7th August 2026

F.A.O. Simon Davis, Principal Planning Officer

Reserved Matters Application AL/27/26/RES
Land West of Lidsey Road (A29), Lidsey

36WJ01

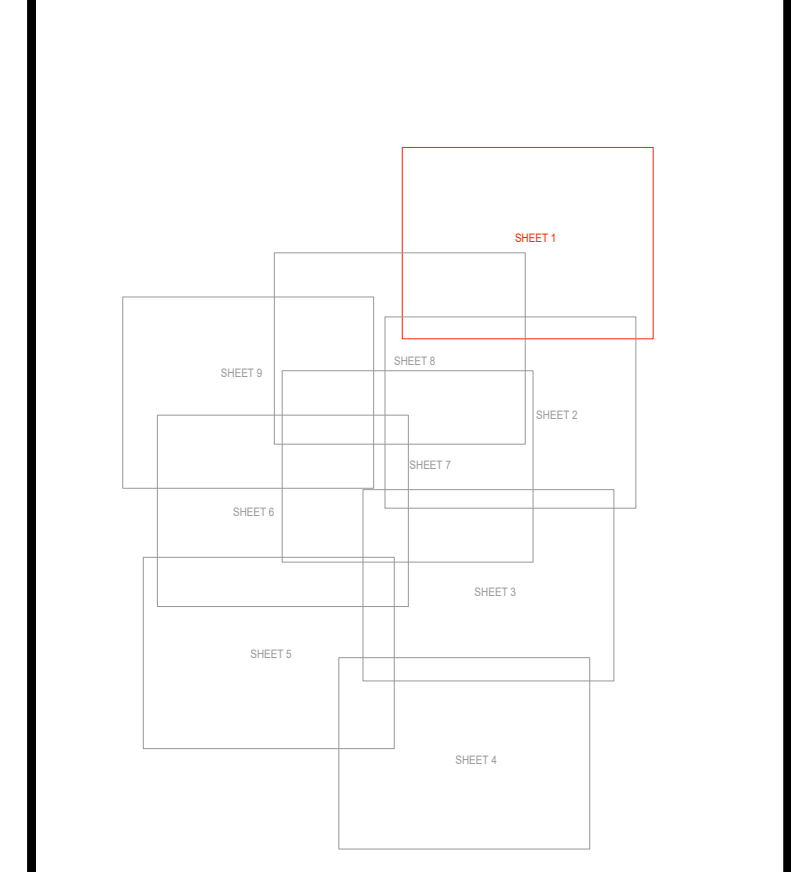
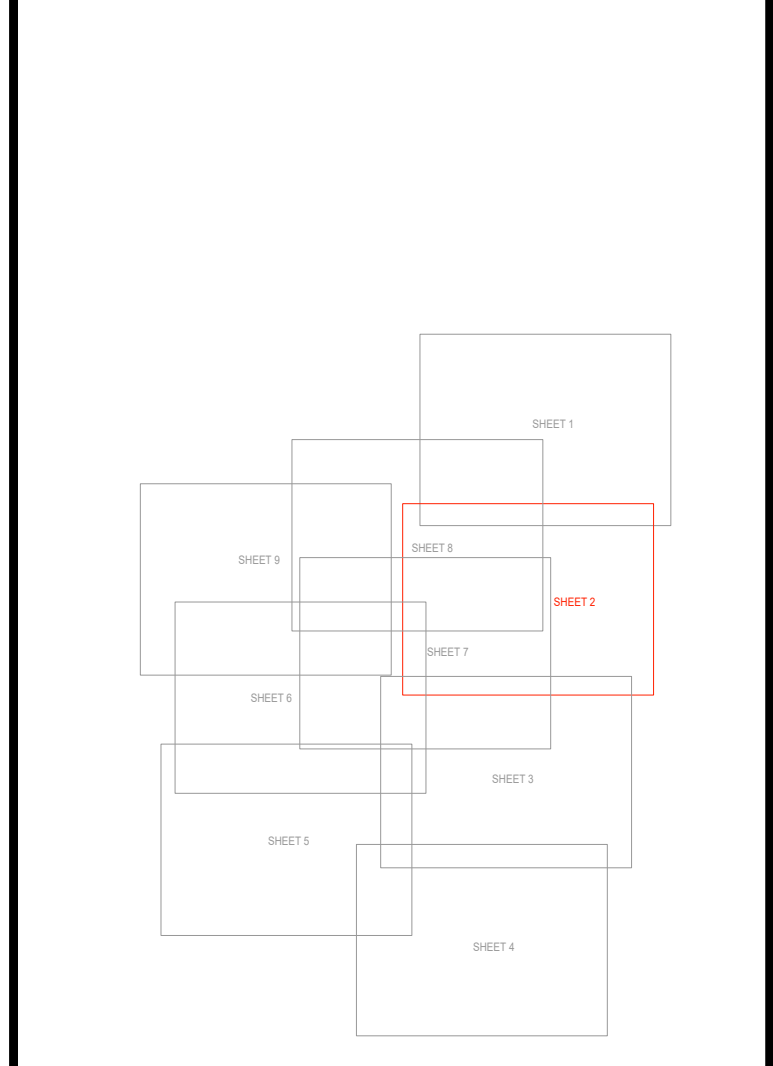
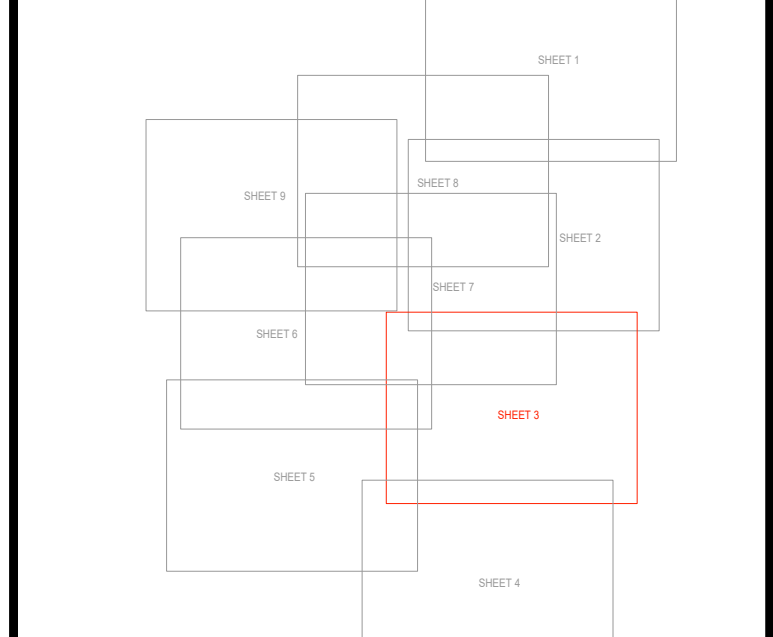
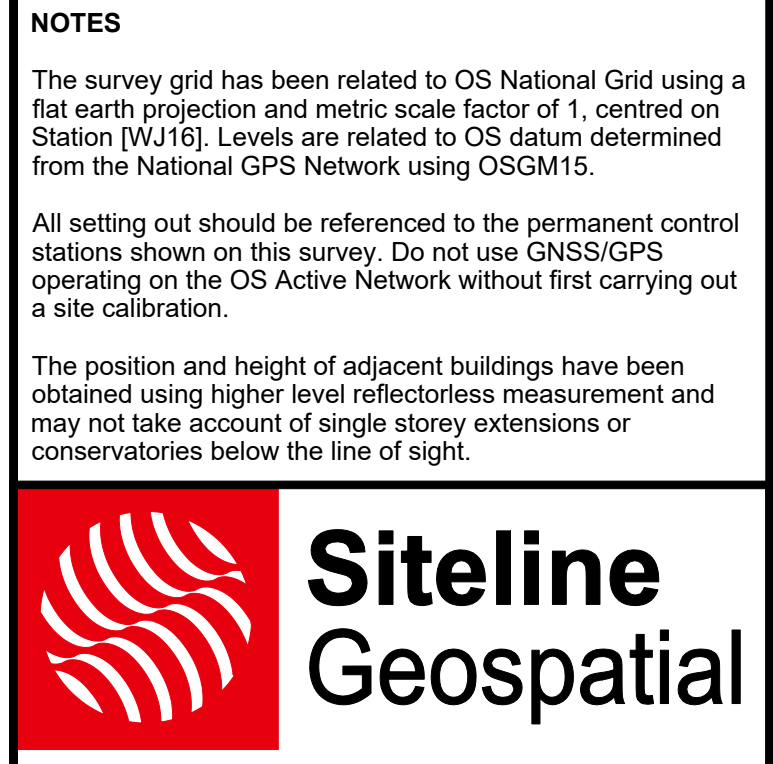
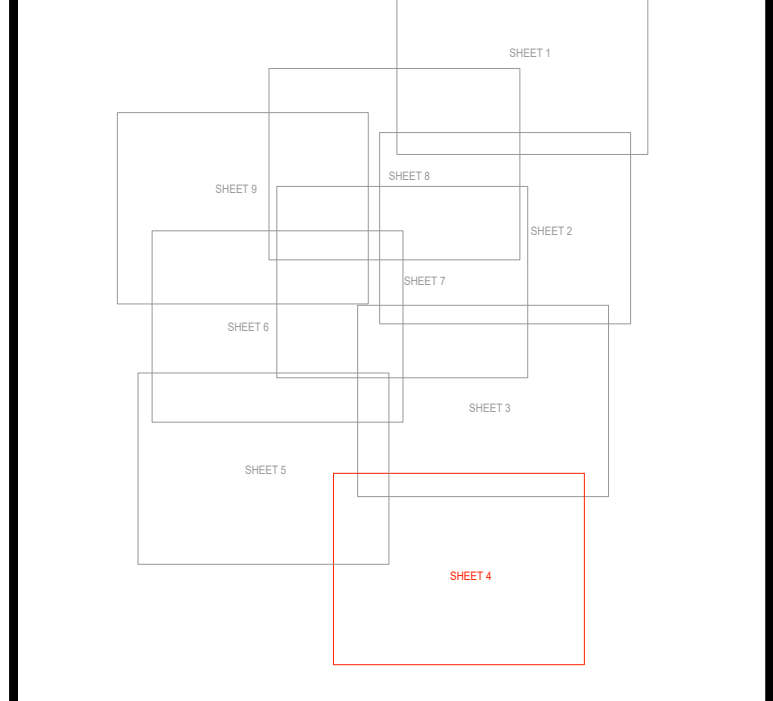
- Levels, comment regarding existing levels information
Response: Topographic survey drawings 36WJ01, Sheets 1-9 were submitted by email on 5th June 2026, which identify existing levels information
